From: Daun Johnson on behalf of Planning.Responses
Sent: 26 October 2018 09:42
To: Planning Scanning
Subject: FW: Planning Consultation on: BR/222/18/PL
Attachments: Drainage - Supplementary Guidance Notes.pdf

Engineers Comments Regarding Surface Water Drainage

APPLICATION NO: **BR/222/18/PL**

Description of Works: Erection of 4no. 2 bedroom dwellings with associated parking
& landscape.

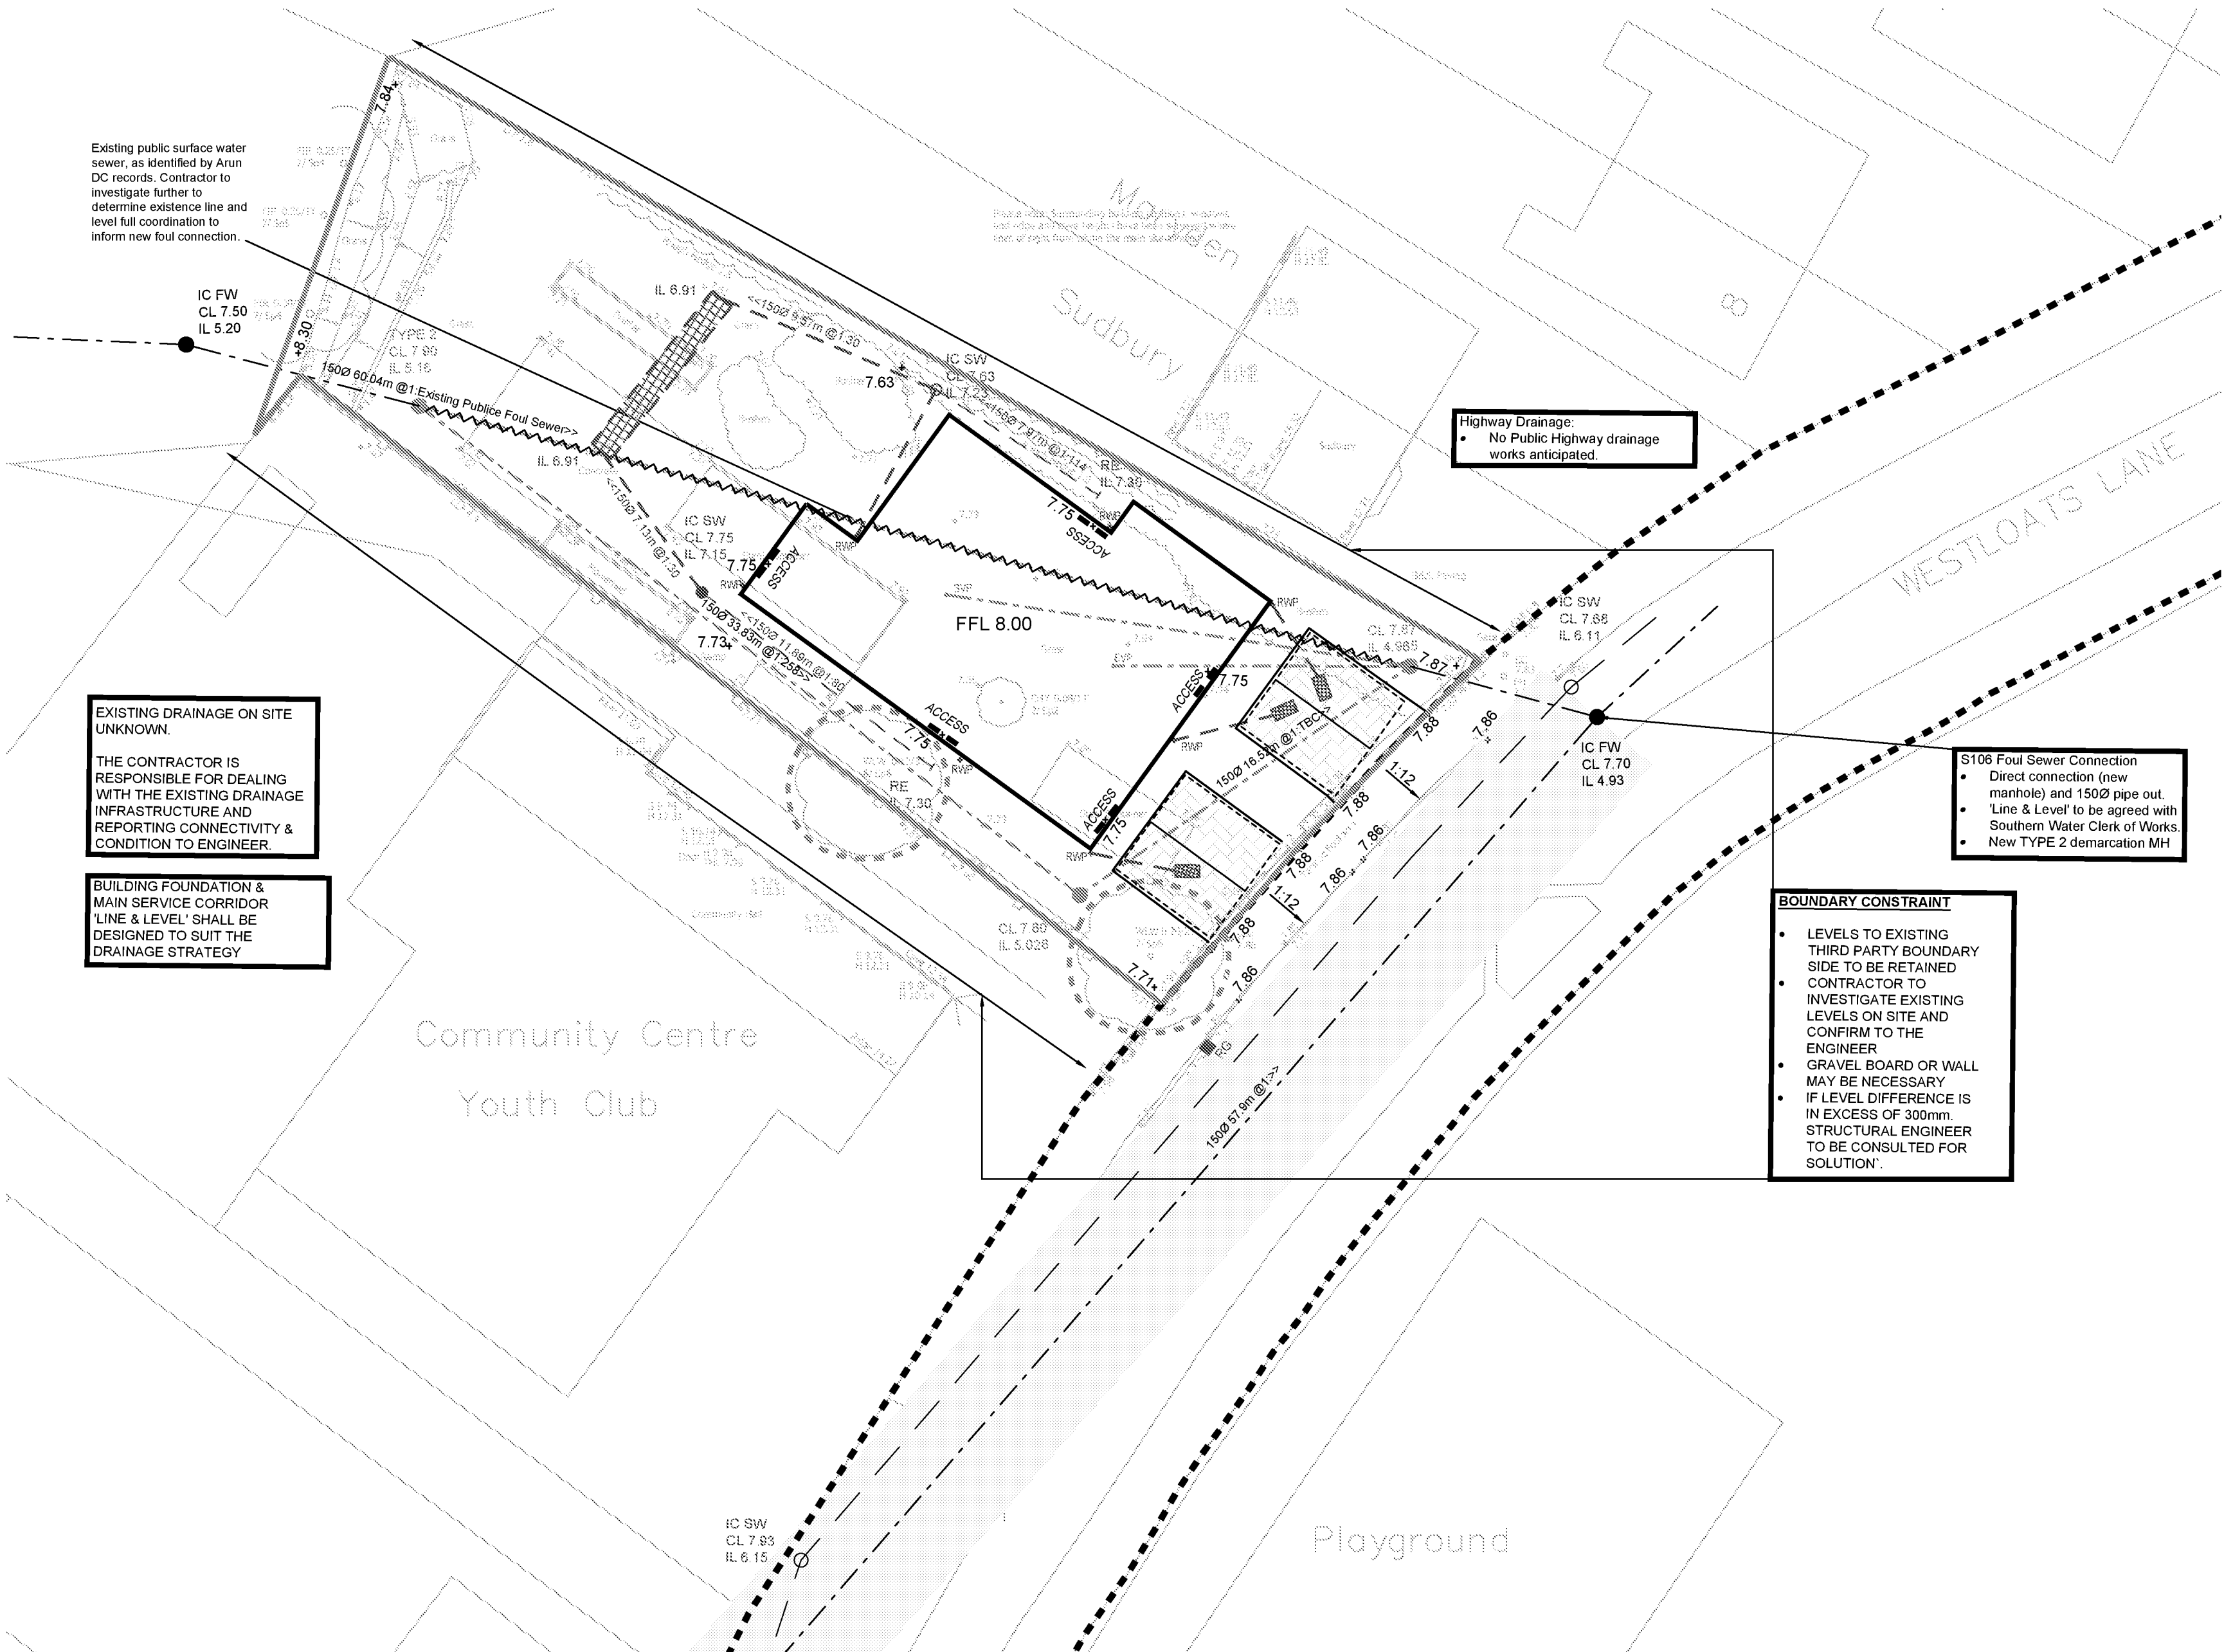
The applicant has submitted preliminary drainage proposals which presume an infiltration rate of 1×10^{-5} . I suspect that the actual rate found during winter testing will be lower than this. Winter groundwater monitoring should also be completed to ensure that the base of infiltrating structures is set above the maximum groundwater level.

Infiltration rates for soakage structures are to be based on percolation tests undertaken in the winter period and at the location and depth of the proposed structures. The percolation tests must be carried out in accordance with BRE 365, CIRIA R156 or a similar approved method and cater for the 1 in 10 year storm between the invert of the entry pipe to the soakaway, and the base of the structure. It must also have provision to ensure that there is capacity in the system to contain below ground level the 1 in 100 year event plus 40% on stored volumes, as an allowance for climate change. Adequate freeboard must be provided between the base of the soakaway structure and the highest recorded annual groundwater level identified in that location.

Any SuDS or soakaway design must include adequate groundwater monitoring data to determine the highest winter groundwater table in support of the design. The applicant is advised to discuss the extent of groundwater monitoring with the Council's Engineers. Supplementary guidance notes are also enclosed for information.

Please apply **ENGD2B**.
